7 November 2016

Re: [Smeaton Grange Waste Recycling and Transfer Facility Response to Submissions Report \(SSD 7424\)](#)

FIGURE 4

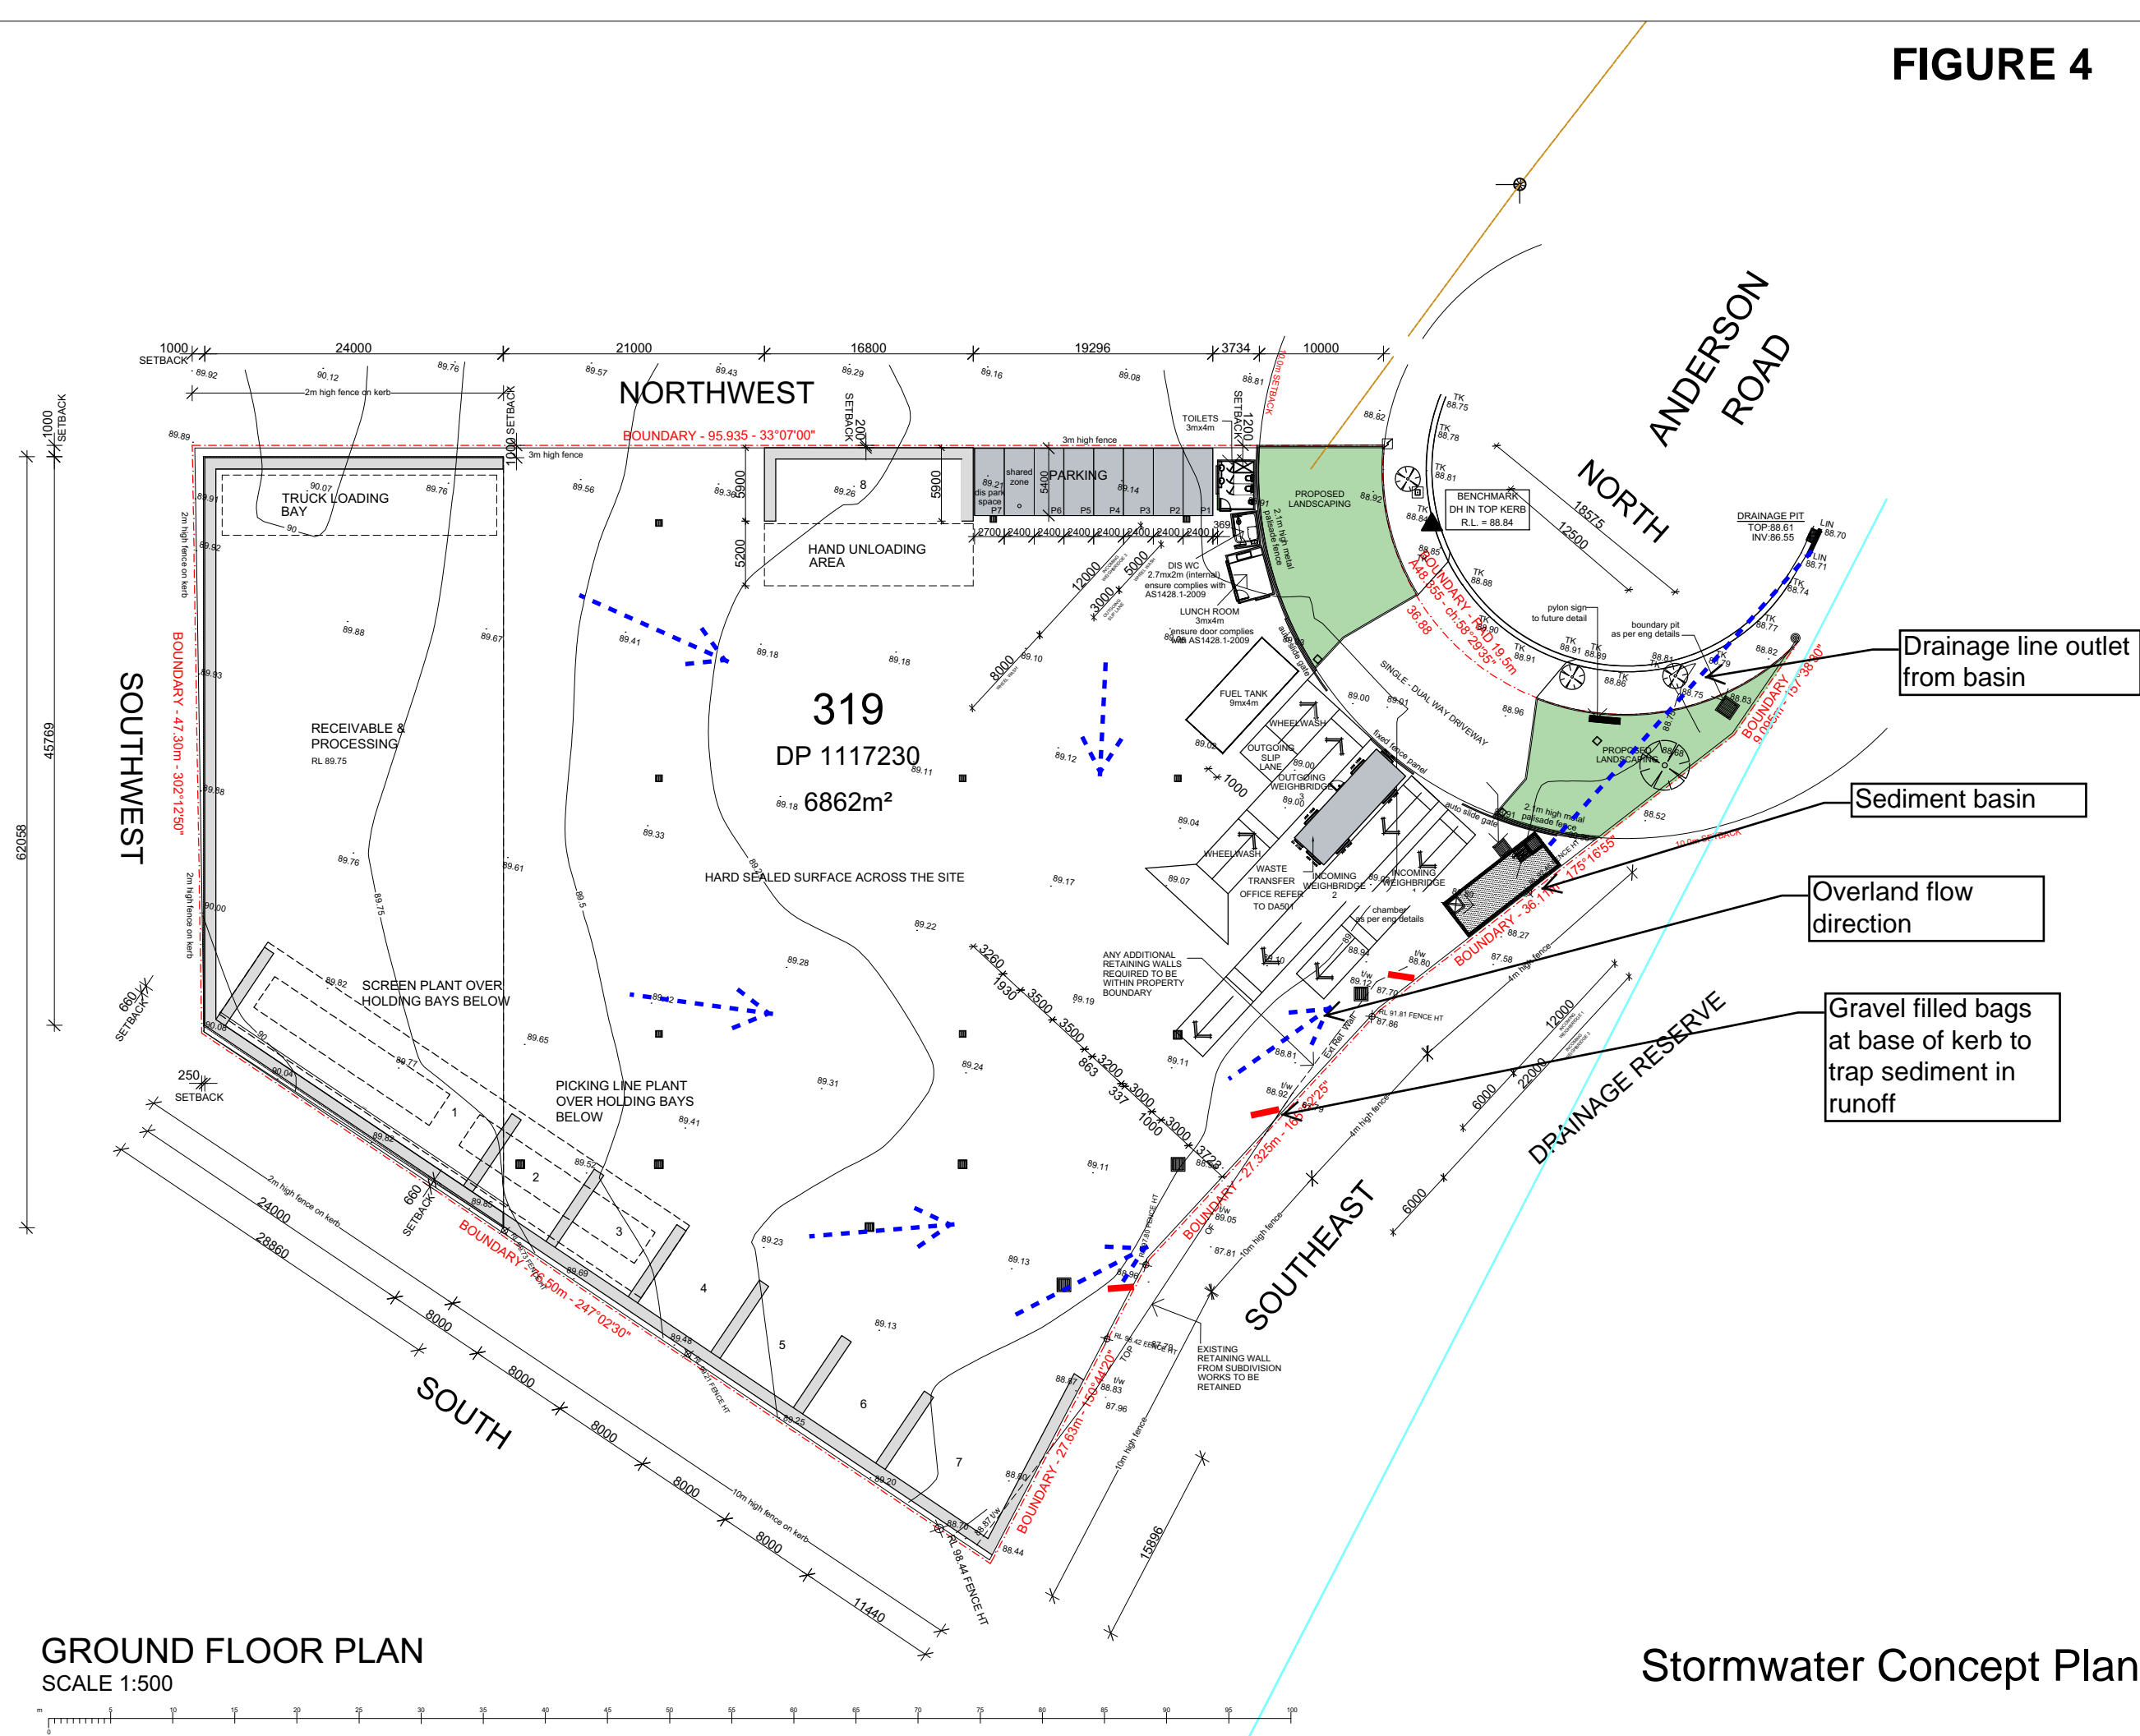
3.2.1.	Noise – ii sleep disturbance	Include measures to mitigate for sleep disturbance or at least reference management measures to minimize impacts.	Additional information is provided in Section 3.2.1
Figure 3.3.	Site Plan	Show on Site Plan Figure 3.3 it would be useful to label storage bays on site plan. Also Indicate storage site for green waste and residual waste for landfill. Indicate where in the shed that bulk light waste and ferrous and non-ferrous metals and green waste would be stored.	The site plan has been updated accordingly.

3.7.5.	vii Overnight bin storage	Provide designated bin storage given that vehicles start arriving at 6am and would need clearances for manoeuvring around on site.	The site plan (Figure 3.3 updated to include a bin storage area and the Section 3.7.5vii amended accordingly.
